From: [REDACTED]
Sent: 29 June 2026 08:21
To: Planning
Subject: Planning Application 3/2026/0354

I strongly object to planning application 3/2026/0354.

The proposed two-storey side extension would cause clear and unacceptable harm to neighbouring residential amenity, directly conflicting with Policy DMG1 of the Ribble Valley Local Plan and paragraph 135 of the NPPF (2023).

Proposed Site Plan

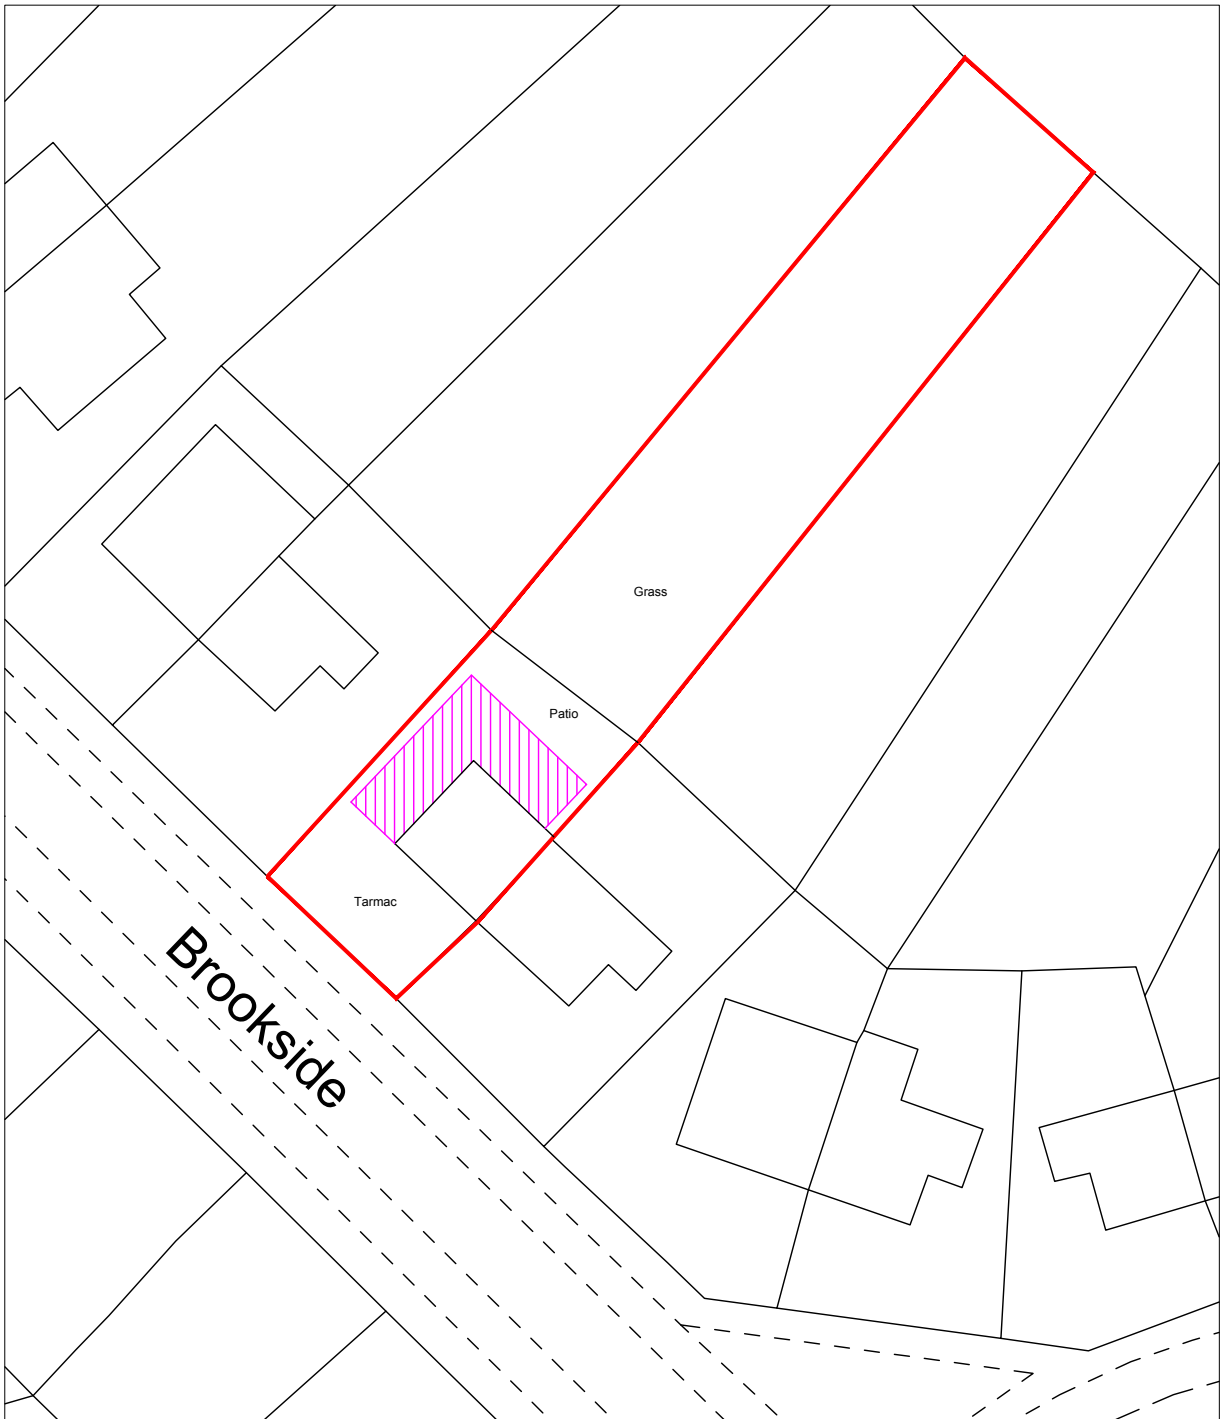
It is also a serious concern that the submitted plans rely on approximate dimensions. Accurate and verifiable measurements are essential for a proper planning assessment, and their absence undermines confidence in the validity of the proposal. The proposed plans approximate sizes do not line up with the land registry map of the property & boundaries – the scale of the extension simply couldn't fit the owned plot of number 13 based on these plans.

Client	Liam Wilson		
Project	13 Brookside, Old Langho 2 Storey Side Extension		
Drawing	Scheme 1 - plans & elevations		
Date	Drawn by	Scales	
April 2026	MJ	1:50	@ A1
Job No - Dwg No - Rev	HA26008 - SK1 - C

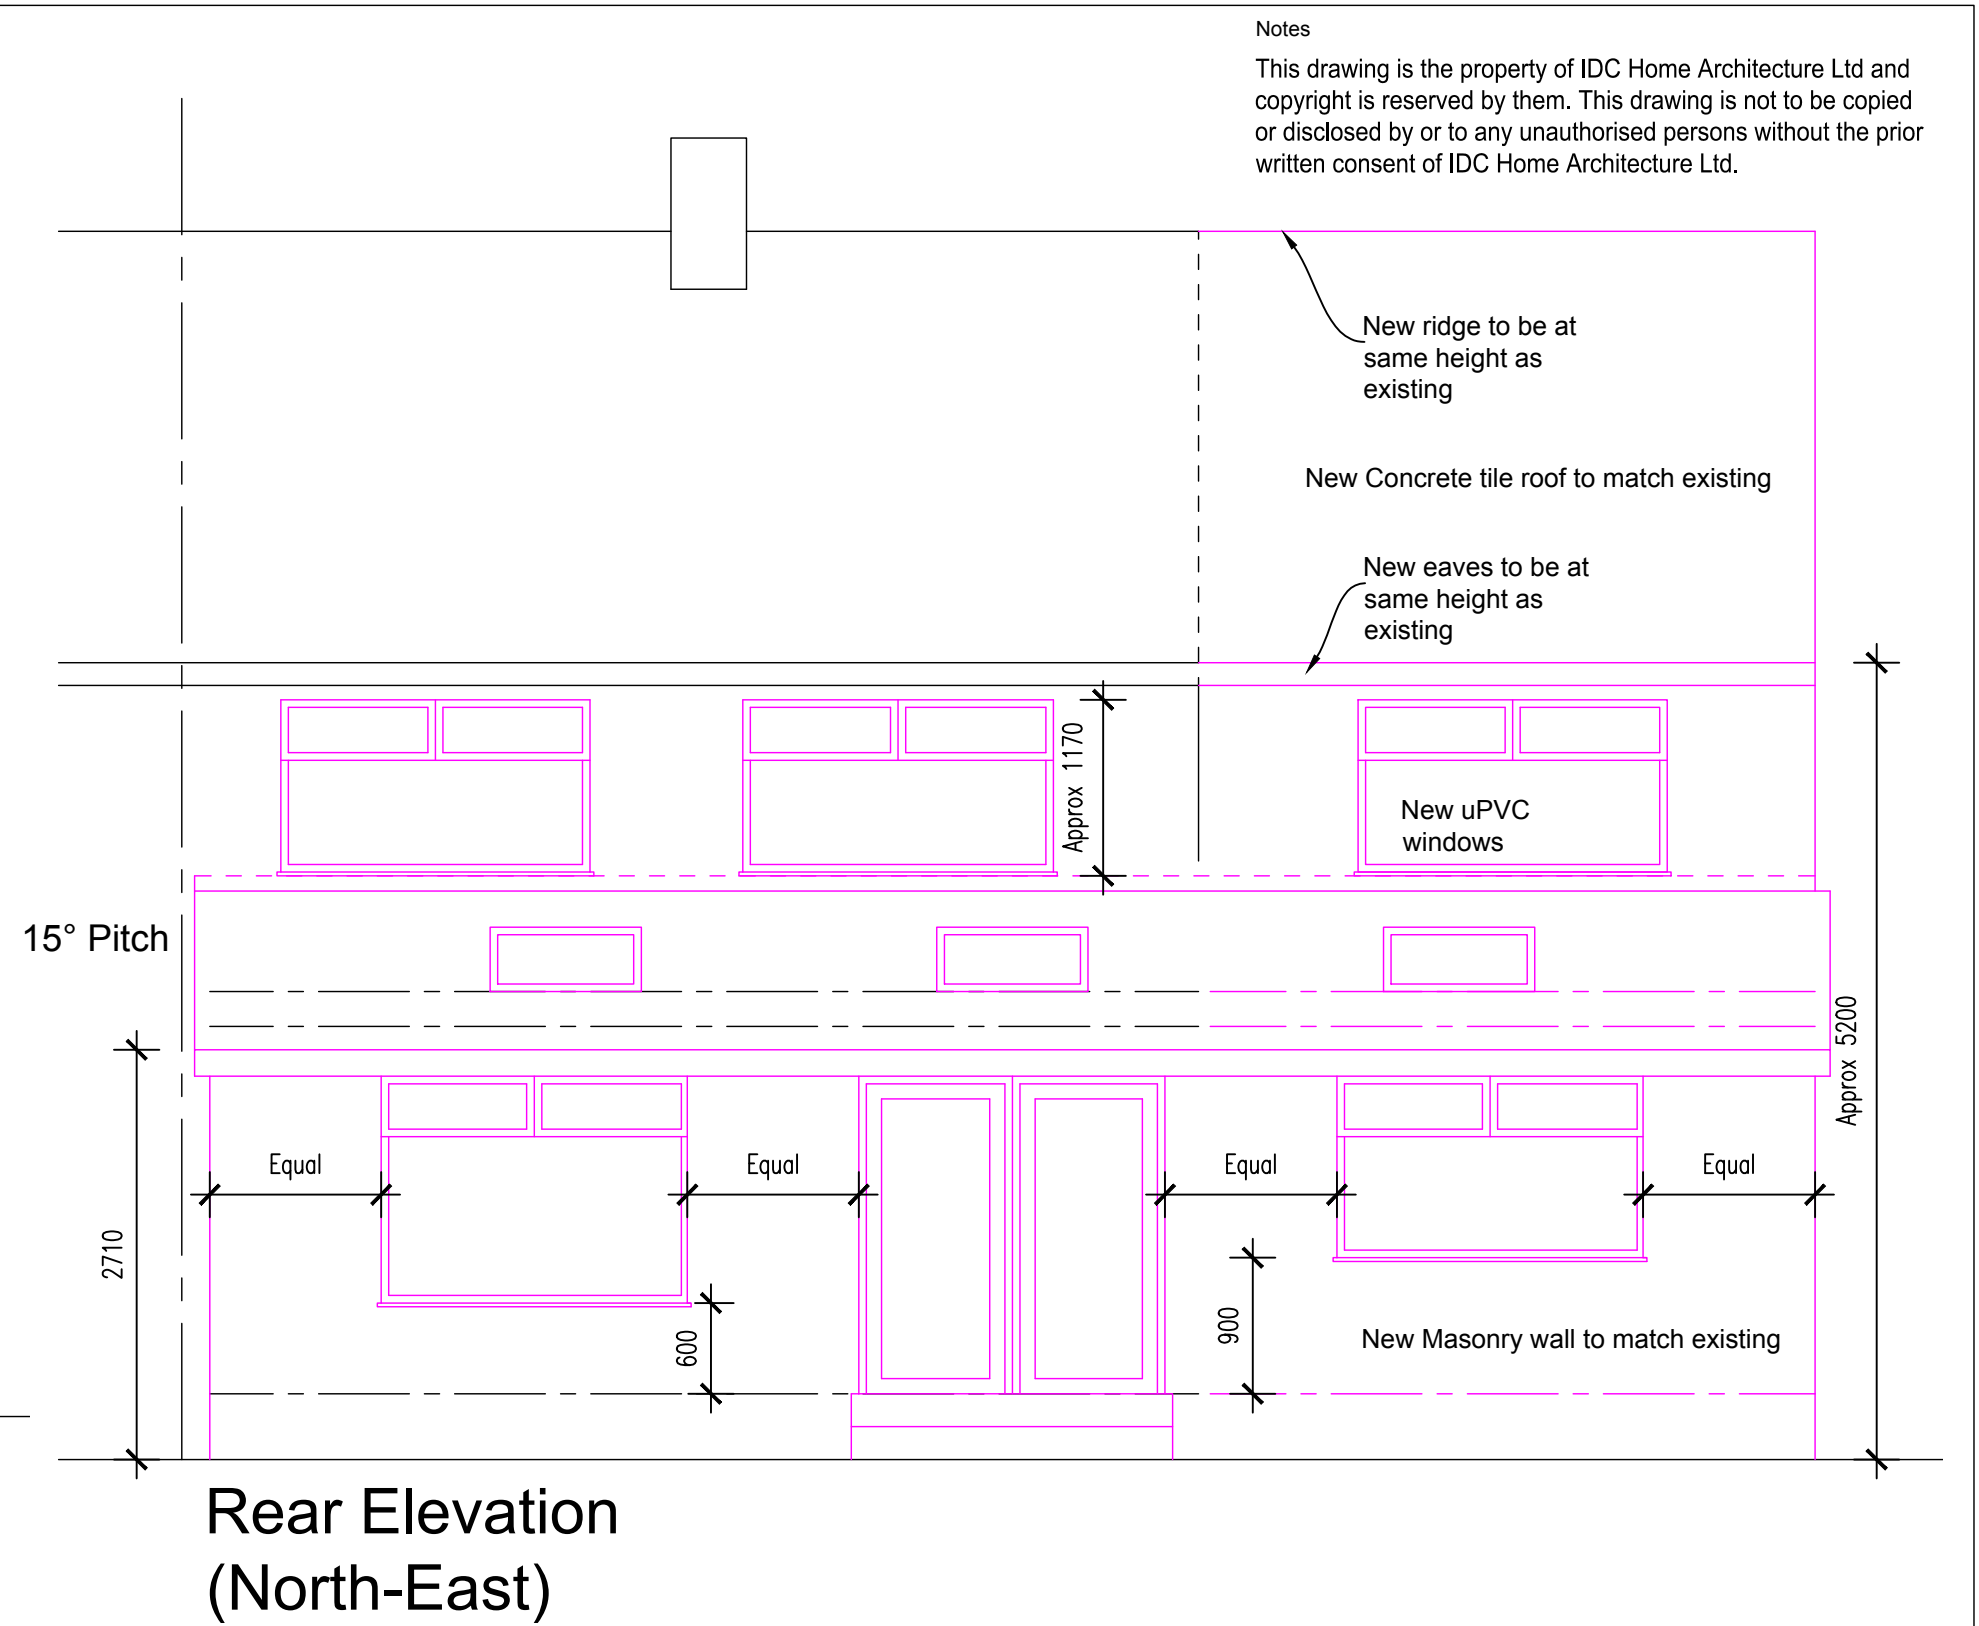
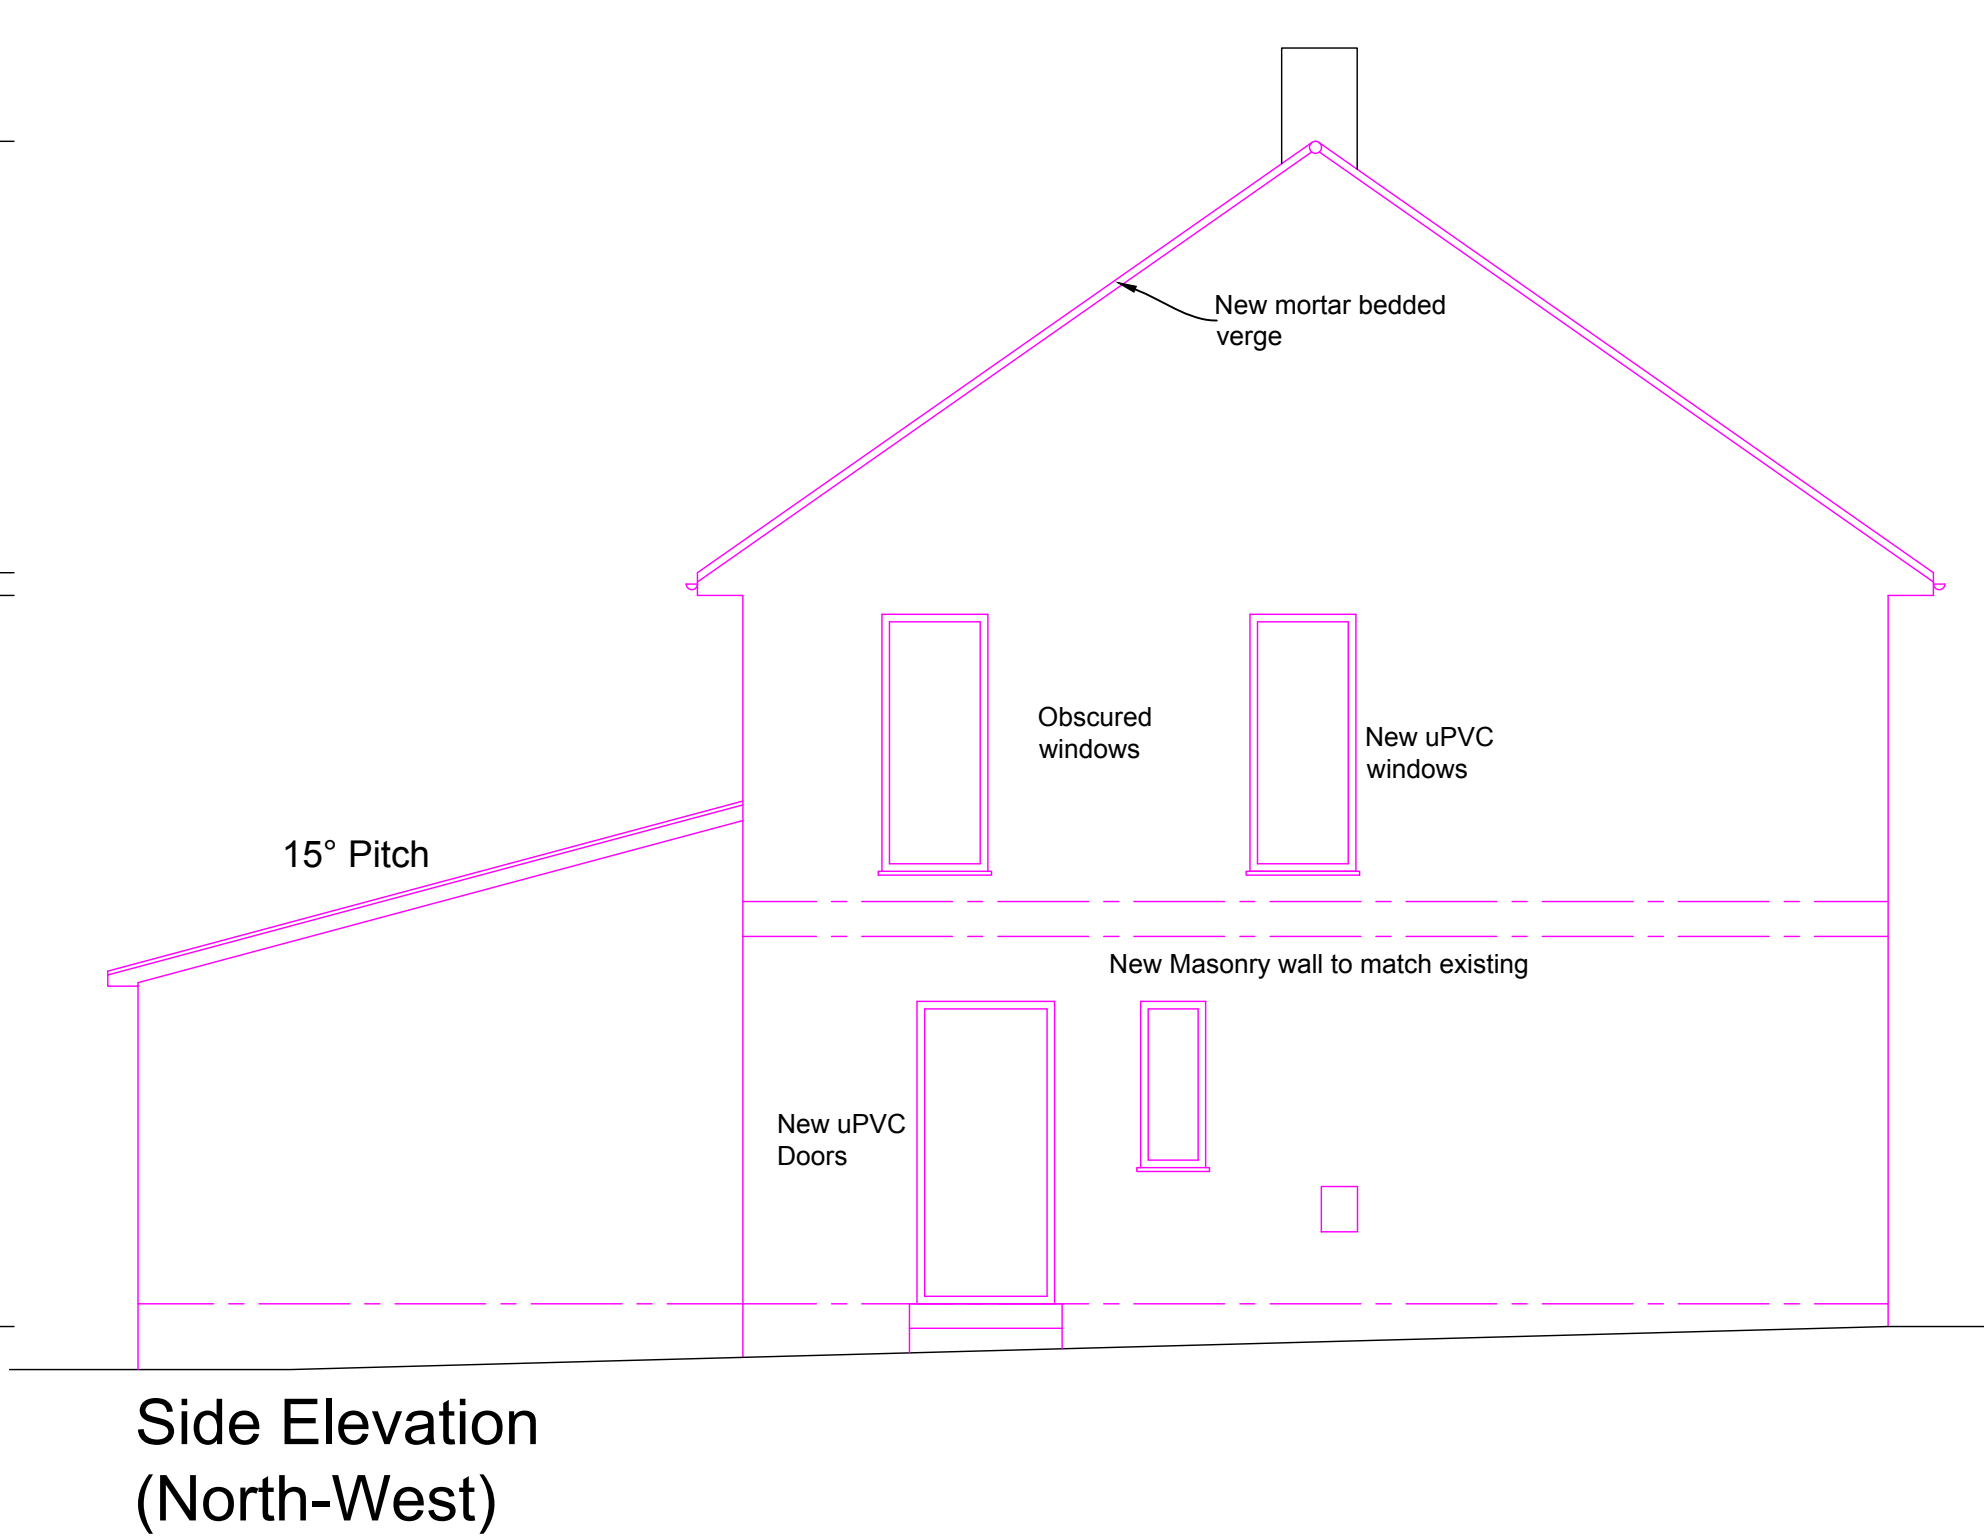
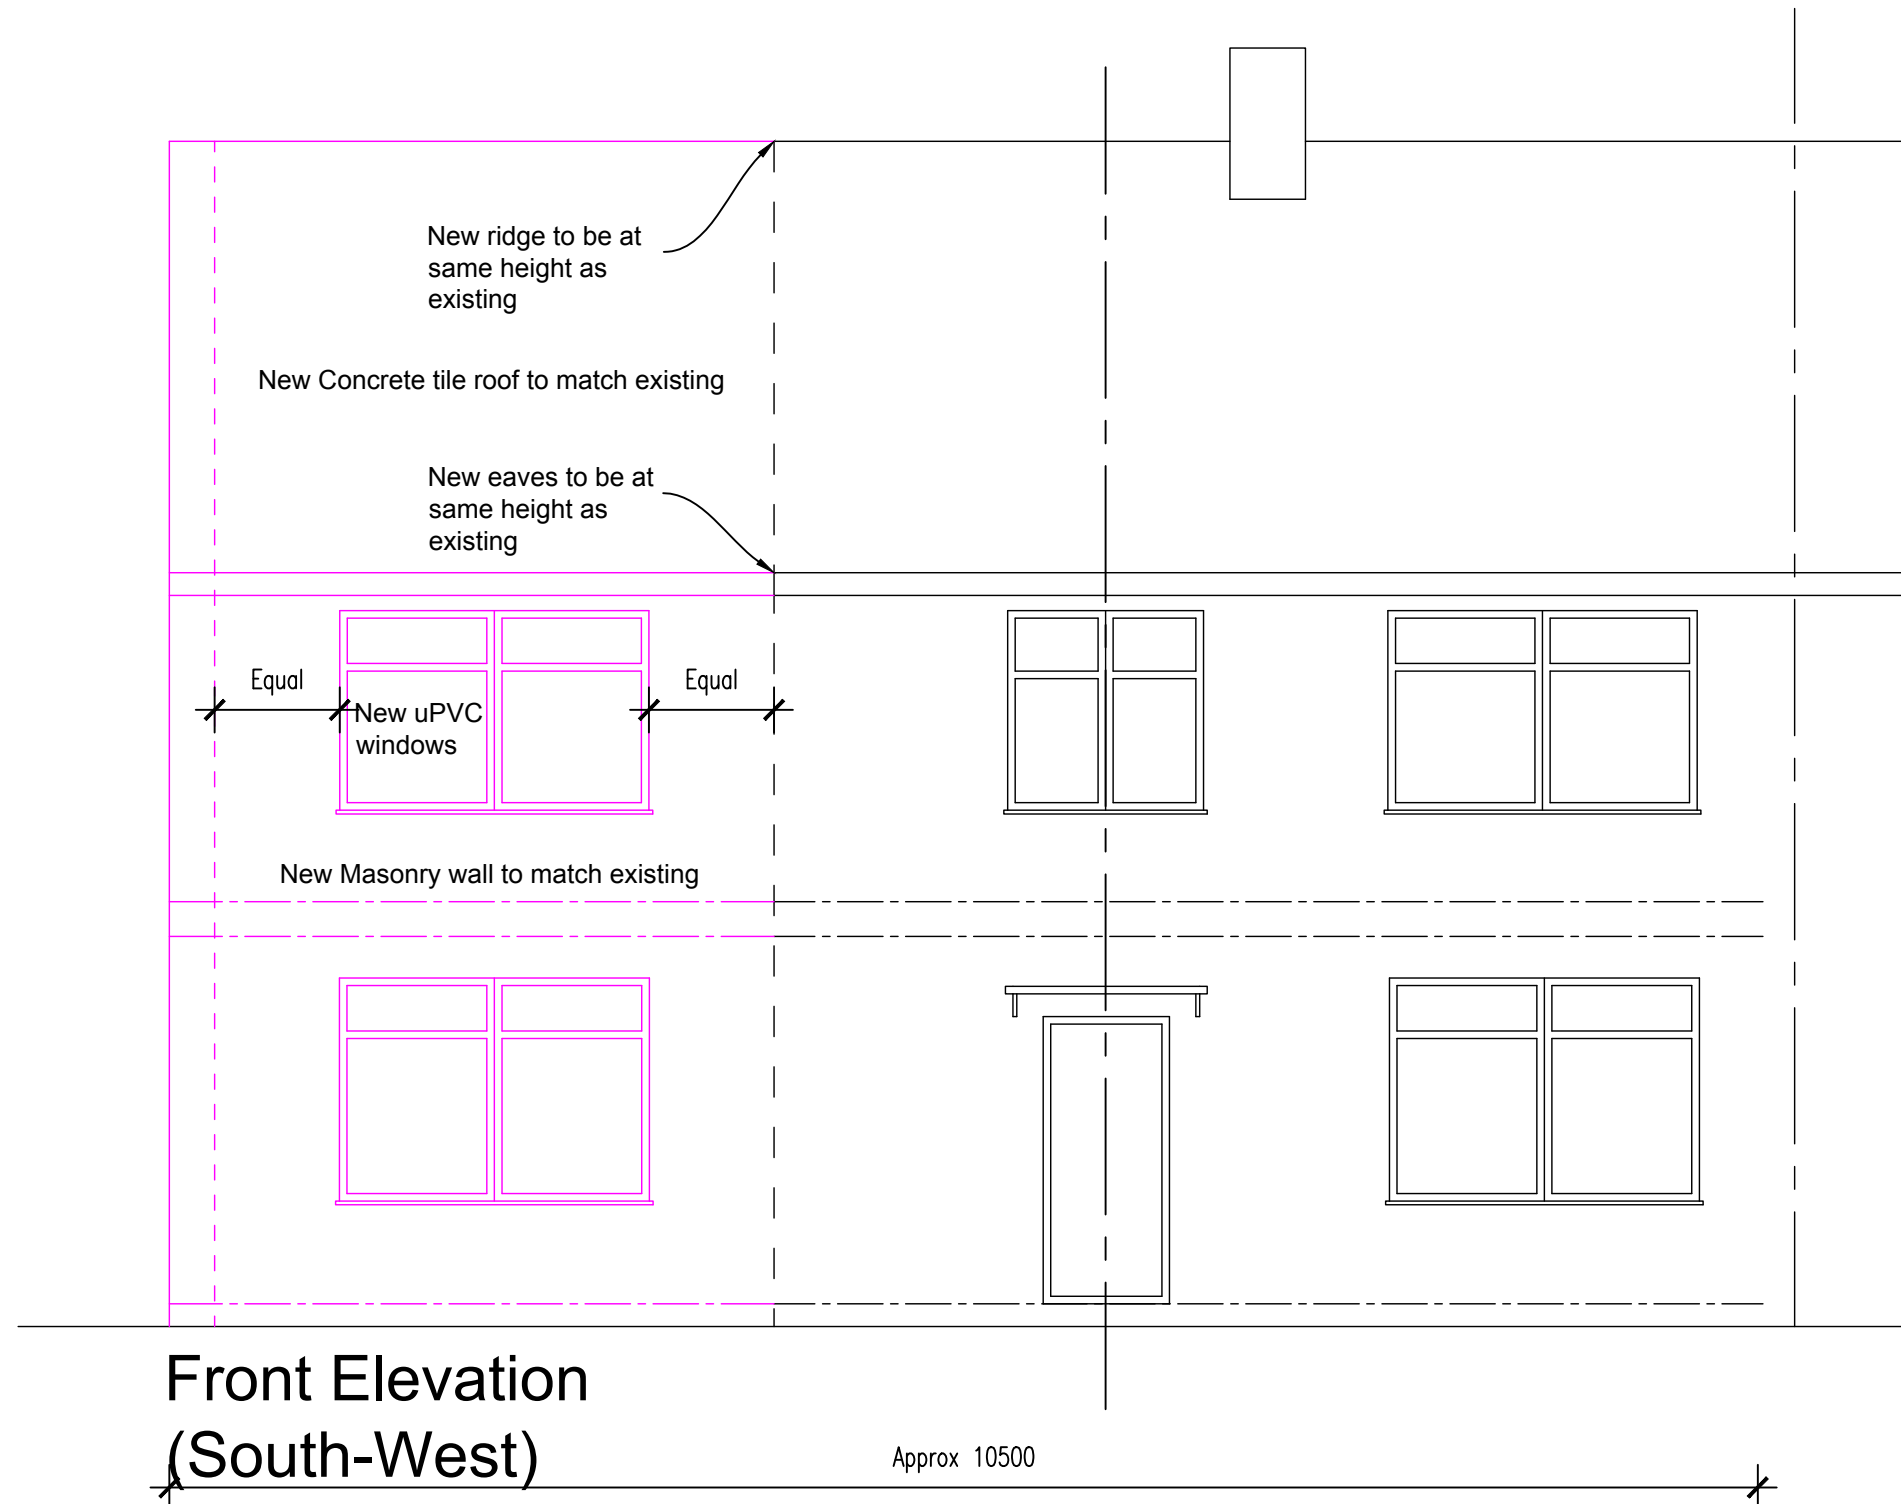
Most significantly, the inclusion of large first-floor side-facing windows is wholly unjustified and unacceptable. These openings, even if obscure-glazed, would directly face neighbouring private garden spaces and introduce an intrusive and overbearing element. Their excessive size further exacerbates this issue and creates an unnecessary and avoidable risk of overlooking.

Secondly the use of full height windows to side elevation seems both intrusive to the adjacent dwelling and also unnecessary in respect that the other extended accommodation on the similar houses have no glazed windows whatsoever to the side elevation. Also seems preposterous to have an unfrosted window in what is to be an ensuite bathroom at the front of the proposed extension.

In addition to these points using the boundaries highlighted in the location plan, given scales and the existing dimensions alongside the proposed dimensions it appears the proposed extension at an overall width of 10.5M is to be either on or extremely close to the boundary of the adjacent property. This would therefore create a both dominant and intrusive structure, not to mention the lack of access to maintain or construct the extension in the first instance. Its my understanding that in accordance with the access to neighbouring land act 1992 any access required for scaffolding, construction or future maintenance such as soffits, guttering or rendering would need to be sought from the occupiers of the adjacent property and that would be categorically denied.
